Sent: 11 January 2013 13:09
To: Planning
Subject: Planning application S6/2012/2608/MA - Nyn Park, Well Road

Response to Planning application from Hertfordshire County Council (T and CP GDP Order 1995)

District ref: S6/2012/2608/MA

Replacement boundary fence to Nyn Park Estate

TITLE
Proposed Boundary Fence (60f6)

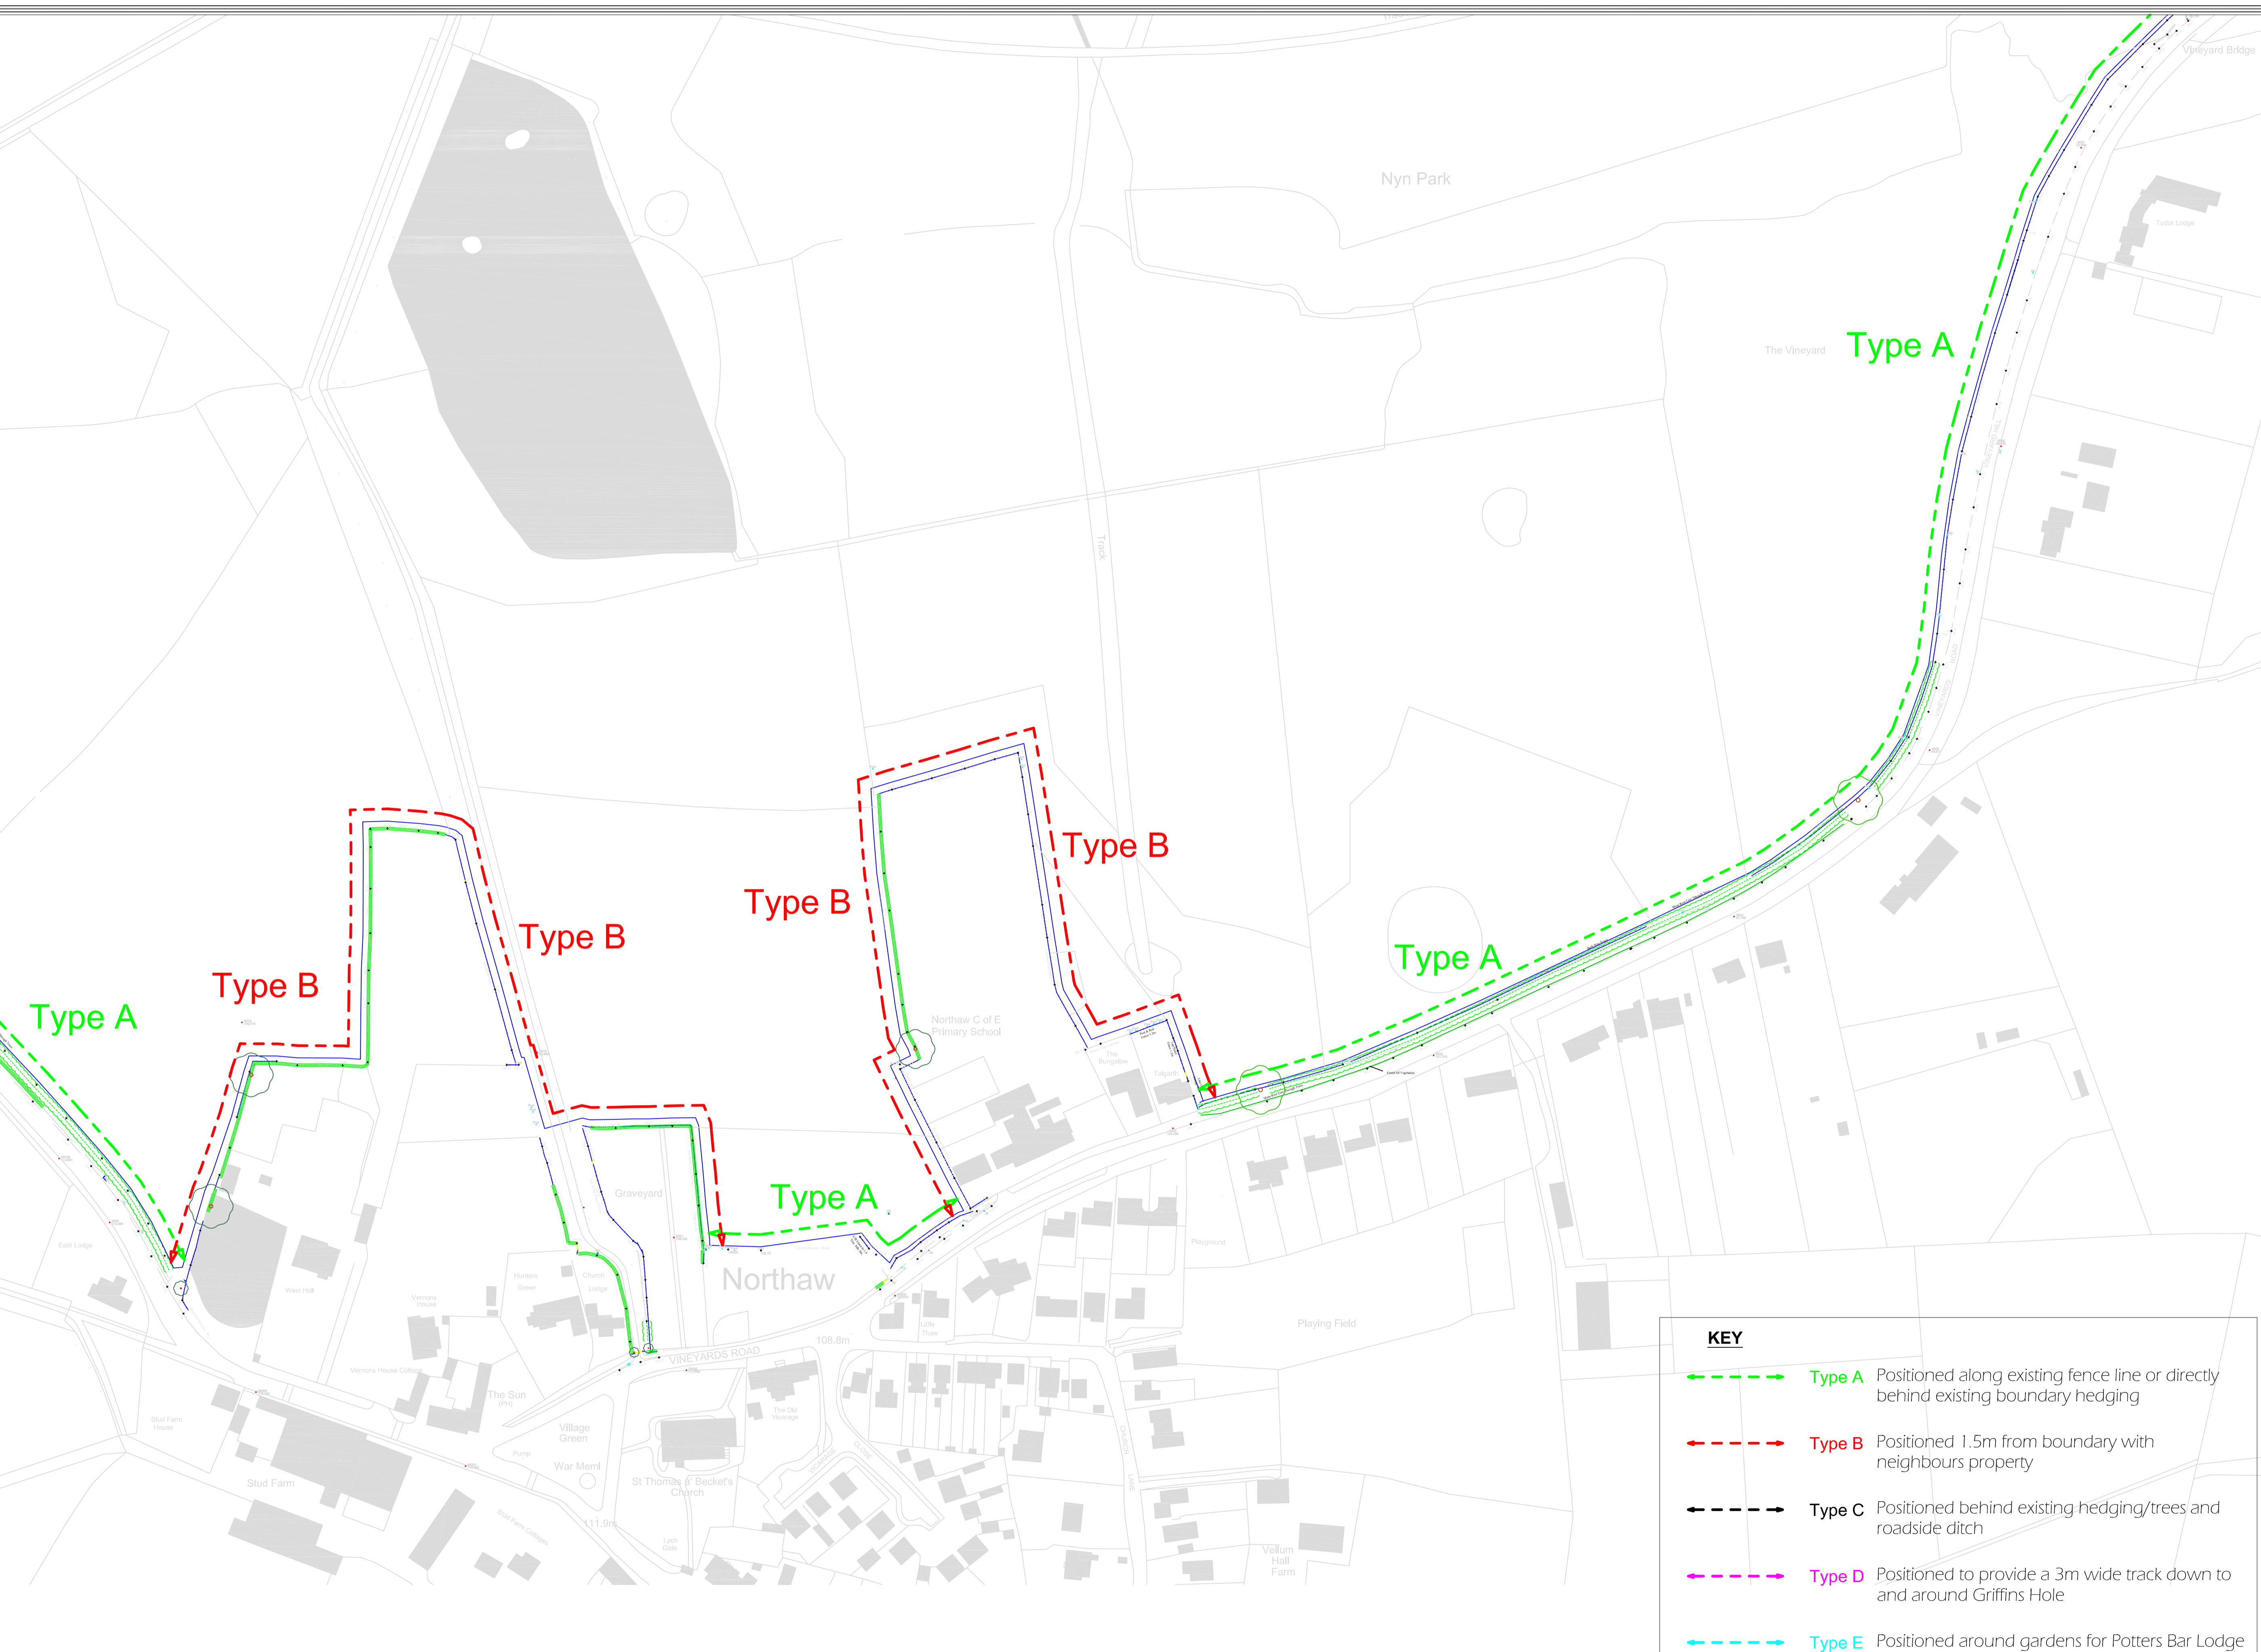
1. No development shall commence until a scheme for the proposed fencing adjacent to the Public Right of way Footpath Northaw 005 has been submitted to and approved in writing by the local planning authority and the County Councils Rights of Way unit. Thereafter the development shall be carried out in accordance with the approved details.

This application is for the installation of replacement boundary fence to Nyn Park Estate. The proposal will include new fencing adjacent to the public right of way, Footpath Northaw 005 which leads to Griffins Hole well. The plans are not detailed enough to show how the proposed fencing will impact on this Right of Way and therefore I recommend the inclusion of the above condition. The proposed fencing should not reduce the width of the existing Right of Way which is approximately 15m and fencing should be placed behind the historic banks which line this route. Details of all work to this part of the boundary should be agreed with the Rights of way unit of Hertfordshire County Council prior to the commencement of the fencing.
